From: David Gallimore [REDACTED]
Sent: 04 May 2020 17:04
To: Paul Cann <Paul.Cann@arun.gov.uk>
Cc: Mike Griffin [REDACTED]; Sarah Burrow <Sarah.Burrow@arun.gov.uk>; Planning.Responses <Planning.Responses@arun.gov.uk>; Michael Eastham <Michael.Eastham@arun.gov.uk>
Subject: RE: Planning Consultation on BE/21/20/DOC

From: Paul Cann <Paul.Cann@arun.gov.uk>
Sent: 21 April 2020 12:02
To: Planning.Responses <Planning.Responses@arun.gov.uk>
Cc: Sarah Burrow <Sarah.Burrow@arun.gov.uk>
Subject: RE: Planning Consultation on BE/21/20/DOC

APPLICATION NO: BE/21/20/DOC

Site Address: Land At Salt Box West Of Shripney Road Bognor Regis PO22 9NW

SECTION 1-1
CROSS SECTION THROUGH AT-401
SCALE 1:25
(REFER TO C-7010 FOR LOCATION)

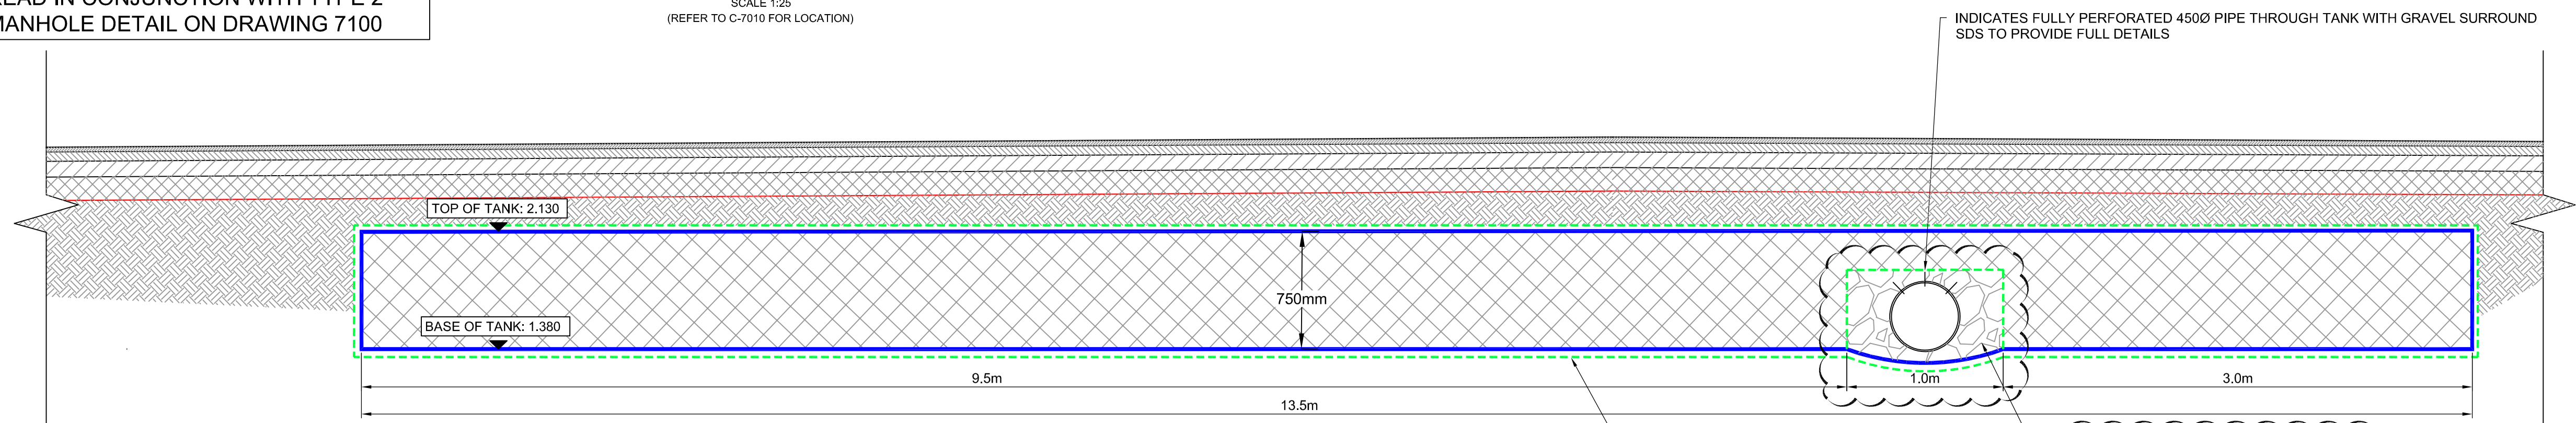
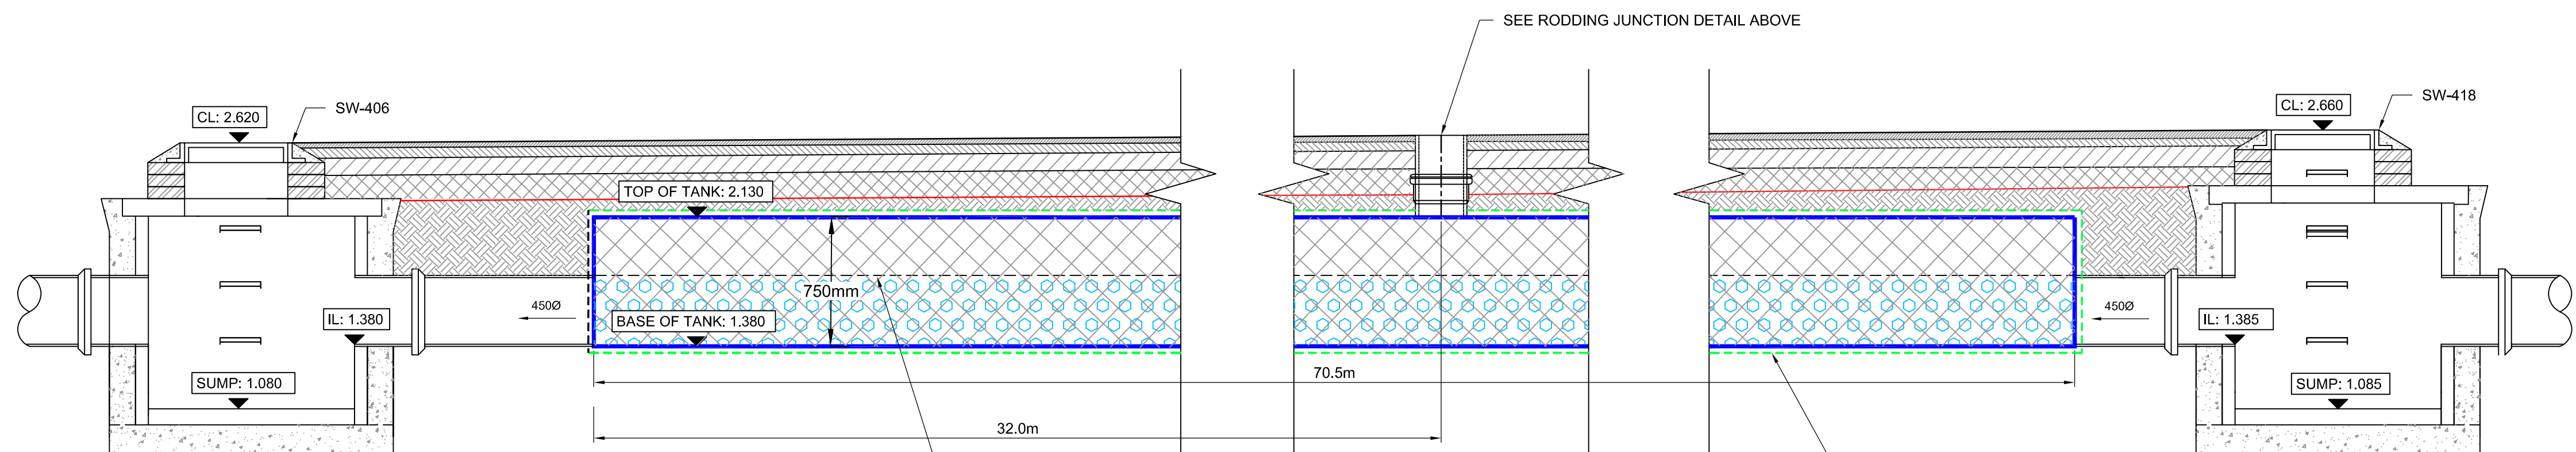
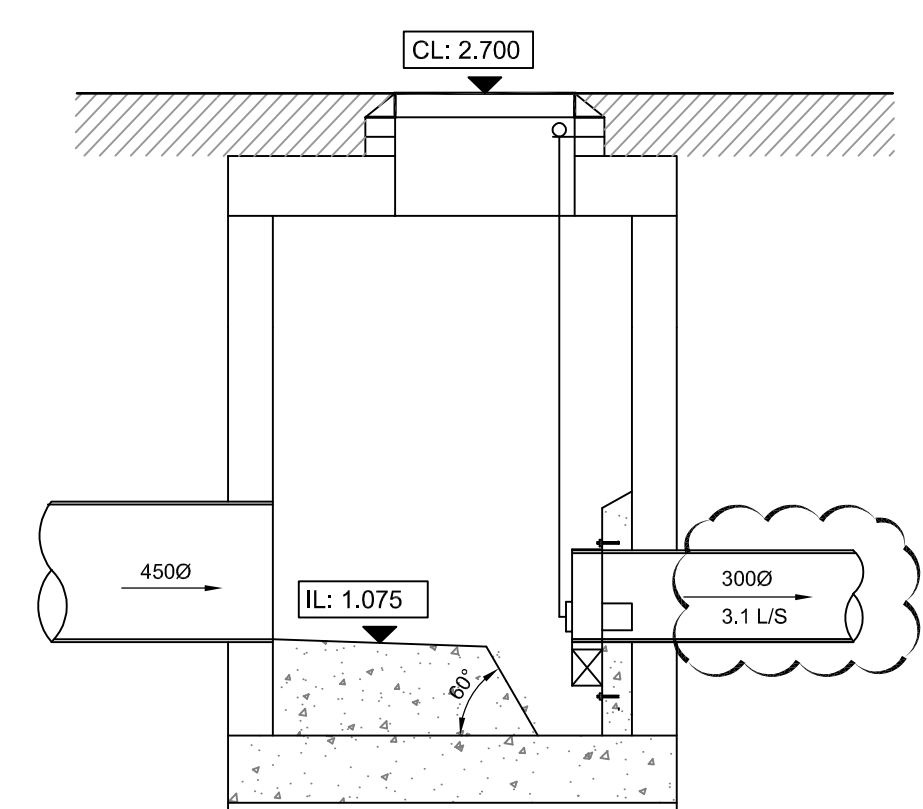
17. Drawings 7103 (Phase 1 & 2) ie. AT-201 and AT-401 – specify granular surround to pipe including thickness. Provide permeable geotextile wrapping to bedding.
Granular material detail note added and permeable textile wrapping note added.

18. AT-401 – Provide integral catchpit manhole in crates at connecting junction as opposed to a 300mm vertical pipe.
SDS tanks do not have a tank spec that allows for manholes to be installed within the tank but can provide a rodding access similar to what is shown and they allow for junctions in the pipe.

SECTION 1-1
CROSS SECTION THROUGH AT-401
SCALE 1:25
(REFER TO C-7010 FOR LOCATION)

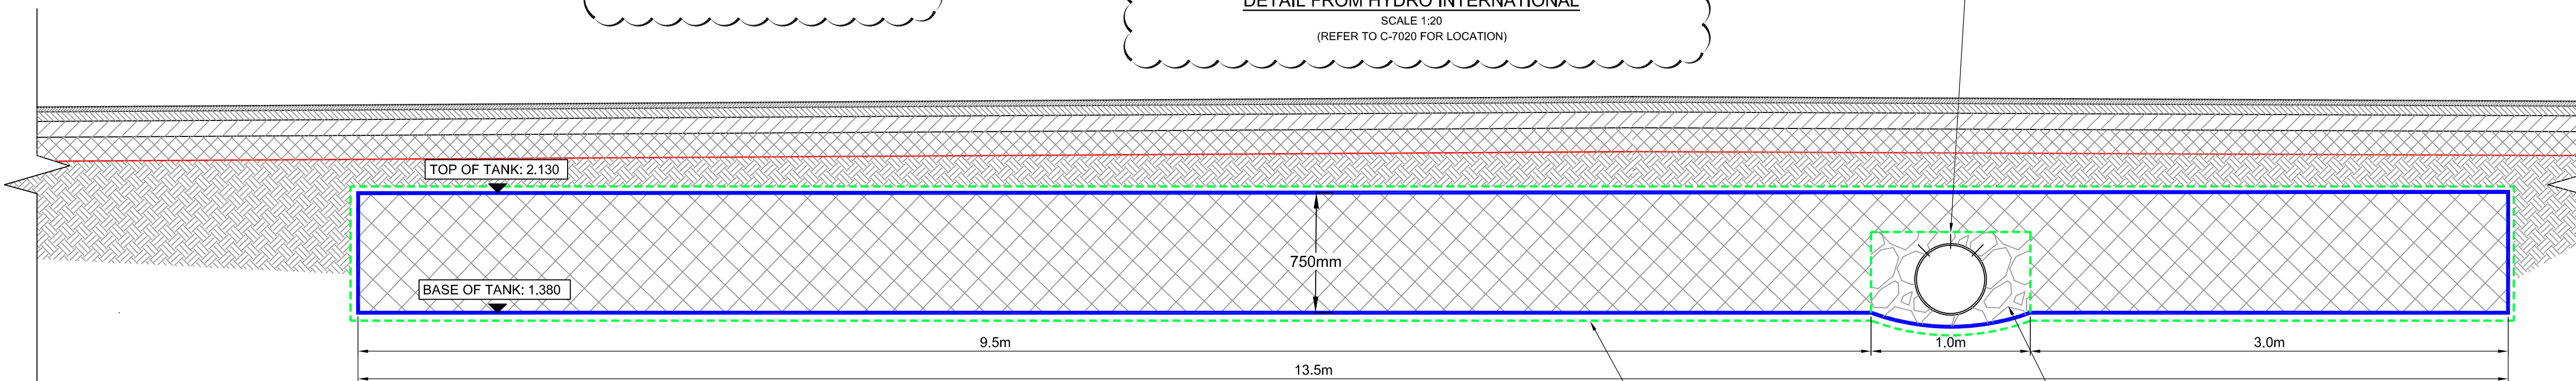
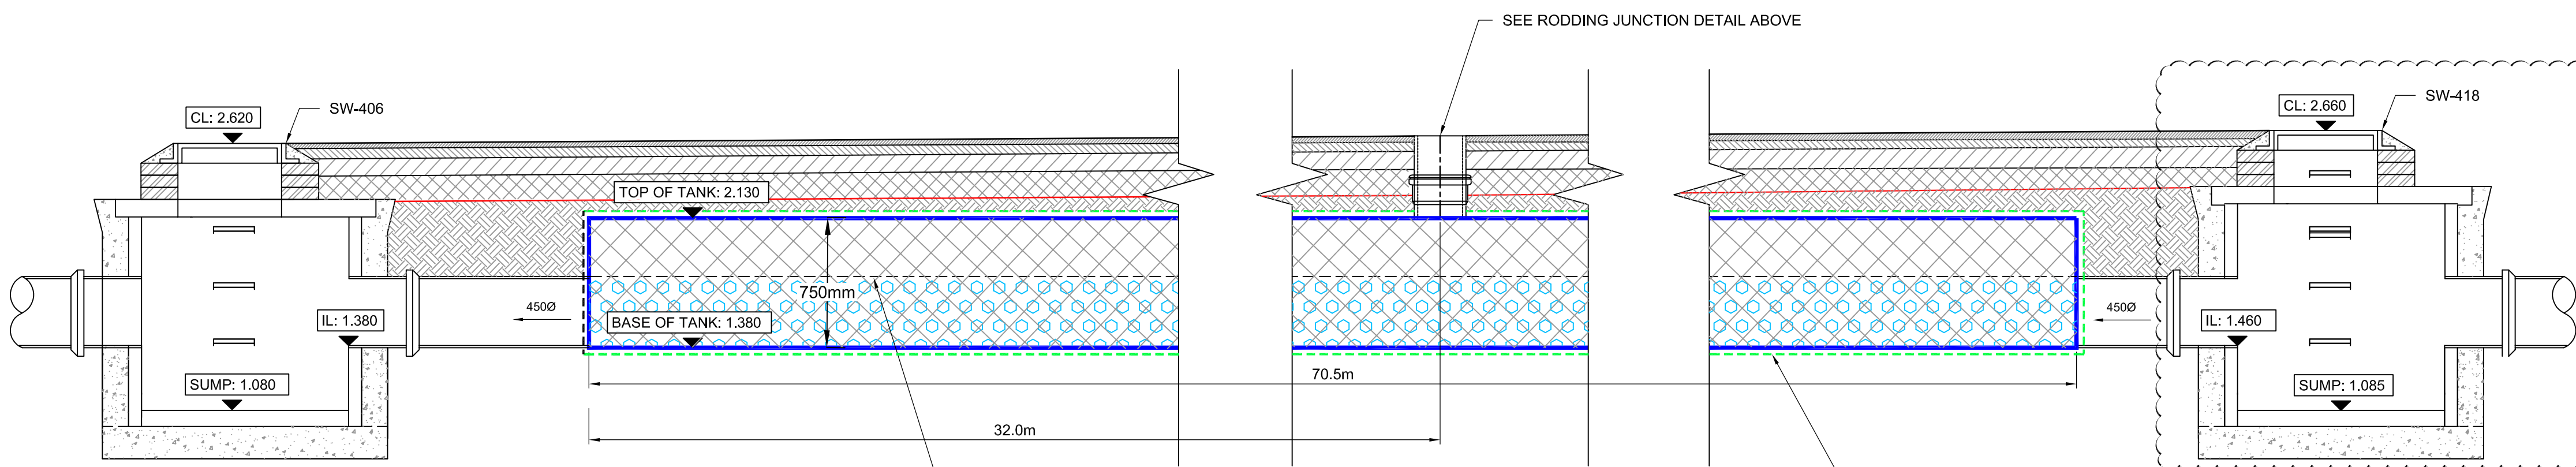
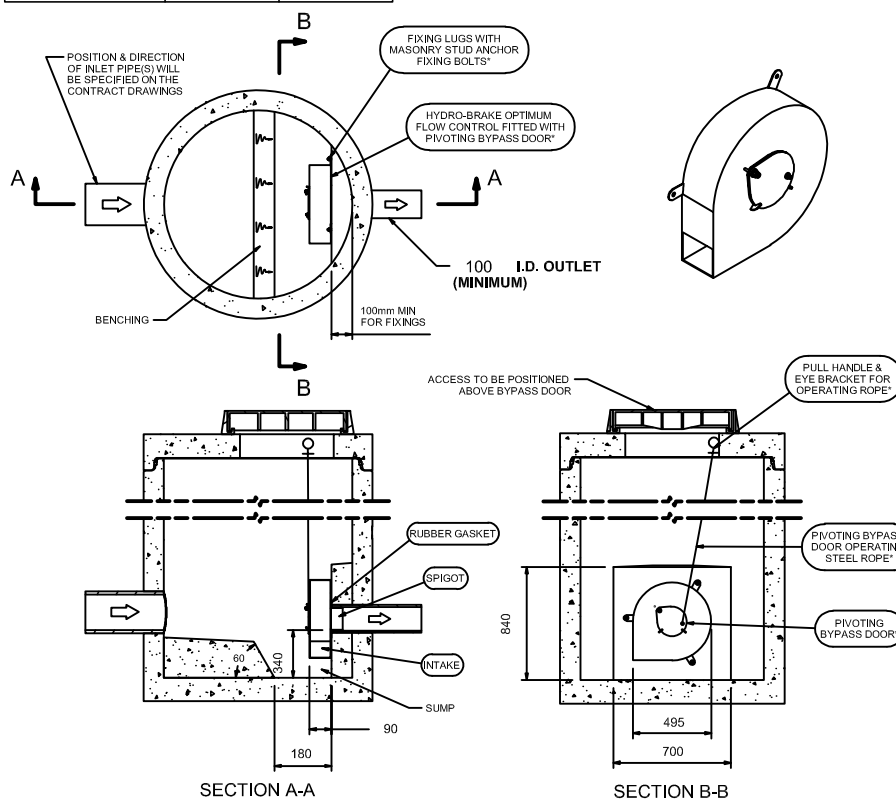
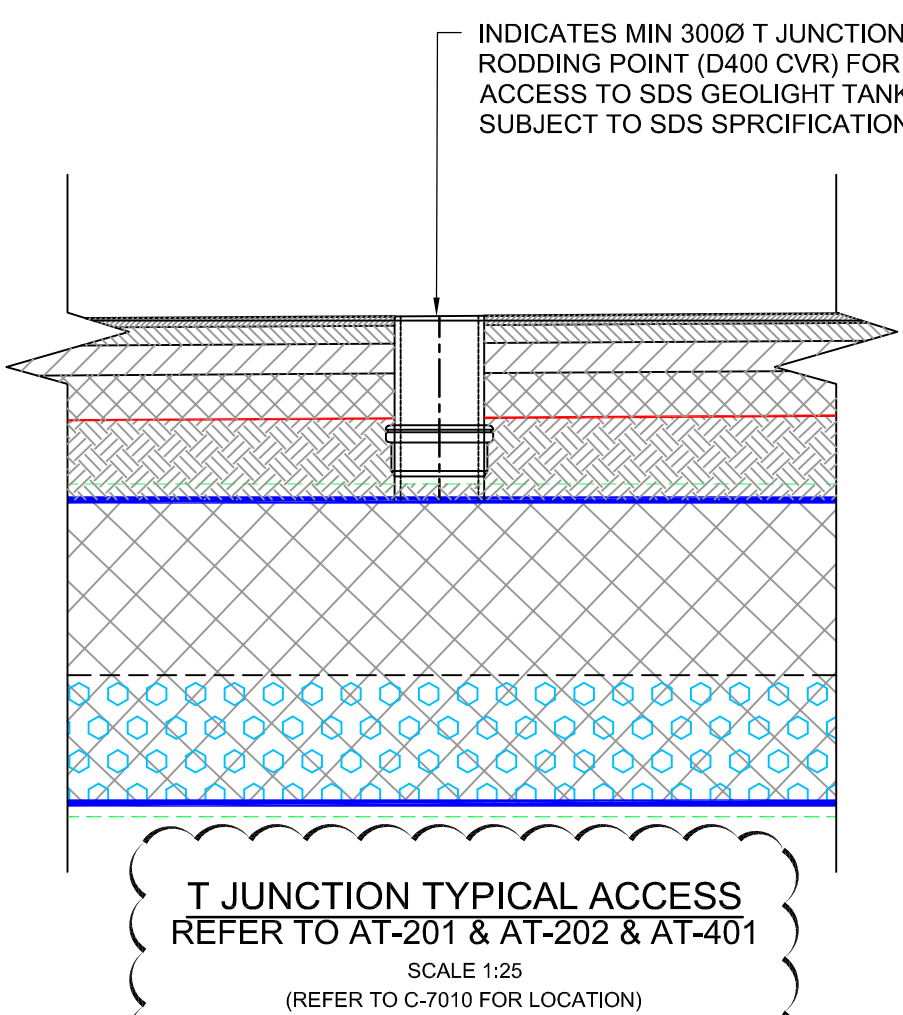
15. Drawing 7010 - SW-405 to tank – specify pipe diameter and a reasonable gradient.
Gradient added
16. Drawing 7103 (Phase 2)– Section 2-2 – should this be labelled AT-401?
401 label added.

20. Improve gradients SW-418 to SW-406.
Minimum gradient added.
21. SW-408 to SW-409 – Specify pipe diameter and gradient.
Gradient added.
22. FC-401 – specify hydrobrake model and discharge on drawing 7103 (Phase 2)
Full detail can be found on drawing 7103. Flow note added.
